**KIRKLEES METROPOLITAN COUNCIL
INVESTMENT & REGENERATION SERVICE**

**DELEGATED DECISION TO DETERMINE APPLICATIONS FOR
CONSENT, AGREEMENT OR APPROVAL REQUIRED BY CONDITION**

Reference No:	2023/44/93175/W
Site Address:	Edgeworth, Main Gate, Hepworth, Holmfirth, HD9 1TJ
Description:	Discharge condition 5 (doors/windows) on previous permission 2021/93813 for demolition of existing funeral home and erection of new dwelling (class C3) with associated landscaping and decked terrace to rear (within a Conservation Area)
Recommending Officer:	Teresa Harlow

S-ribbed (LPU 42, LTE 42), Traffic white RAL 9016

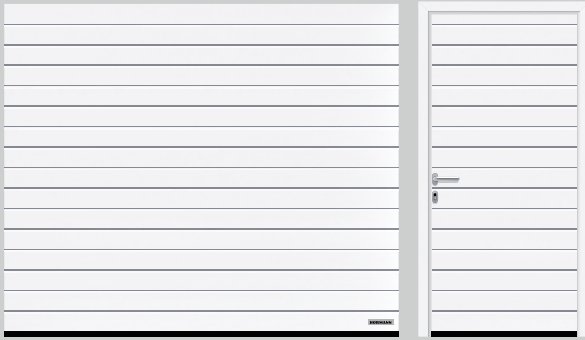
- Having looked through the details, in terms of the preservation of the Conservation Area, we would prefer the door types: S-ribbed (LPU 42, LTE 42), as set out on page 17 of the 86912_GST_Kurzversion_0717_EN door brochure. The door details are shown to be in RAL7016 (Anthracite Grey).

M-ribbed (LPU 67 Thermo, LPU 42, LTE 42), Traffic white RAL 9016

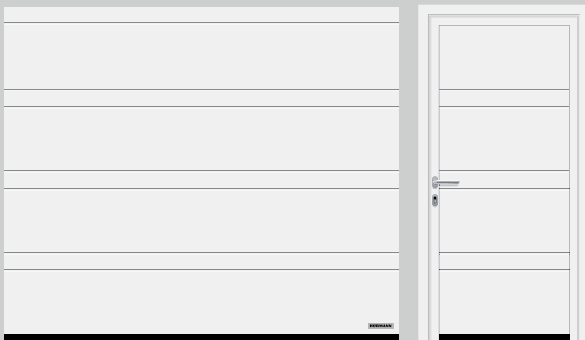
86912_GST_Kurzversion_0717_ENRefer to Page 17, product number: M-ribbed (LPU 67 Thermo, LPU 42, LTE 42) Colour RAL 7016 (Anthracite Grey)

These doors would be of a 'composite' type with 67mm insulation to the garage door. The garage door would have a sectional finish, avoiding an 'up-and-over' type door. The adjacent front door would harmonise with the garage door having the same ribbed effect.

The doors: garage and house, along the front elevation are proposed, as the approved windows, to be finished in anthracite grey and be of a simple modern finish. The composite finish and material would – in the context of this dwelling and the details previously approved – 'respect the traditional context the site sits in'. The site is within the Hepworth Conservation Area and the redevelopment of the site sees the former funeral home replaced with the larger two-storey dwelling. The new dwelling harmonises with the Conservation Area in its detailed finish.

“the M-Ribbed is available in a 67mm thickness, which allows the door to have far better thermal credentials so will assist in the energy efficiency of the build, the S-Ribbed is only available in a 47mm. On top of this I do think the M-Ribbed is far more aesthetically pleasing, the sections are relatively short in comparison to a lot of sectional doors and shorter than others within the conservation area. I do feel the S-Ribbed would give a more cheapened appearance”.

All the above has been taken into account, including the minor differences between the submitted details, the alternative proposal put forward by Conservation and the justification provided by the agent. Weight has been afforded to the modern yet traditional design of the replacement dwelling. The original door specifications (M ribbed) – including the material proposed and the dark grey colour – are considered to retain the visual amenity of the area, to preserve the significance of the Hepworth Conservation Area and nearby Grade II listed buildings. This is provided an eggshell finish is used for the external face of these doors.

The submitted details, are approved in compliance with condition 5, together with the details previously approved under application no. 2023/91631. This is provided the external paintwork of the doors is in an eggshell finish, to match the approved windows. The requirements of condition 5 are that the doors shall now be installed within the dwelling in full accordance with the approved details and shall be retained as such thereafter.
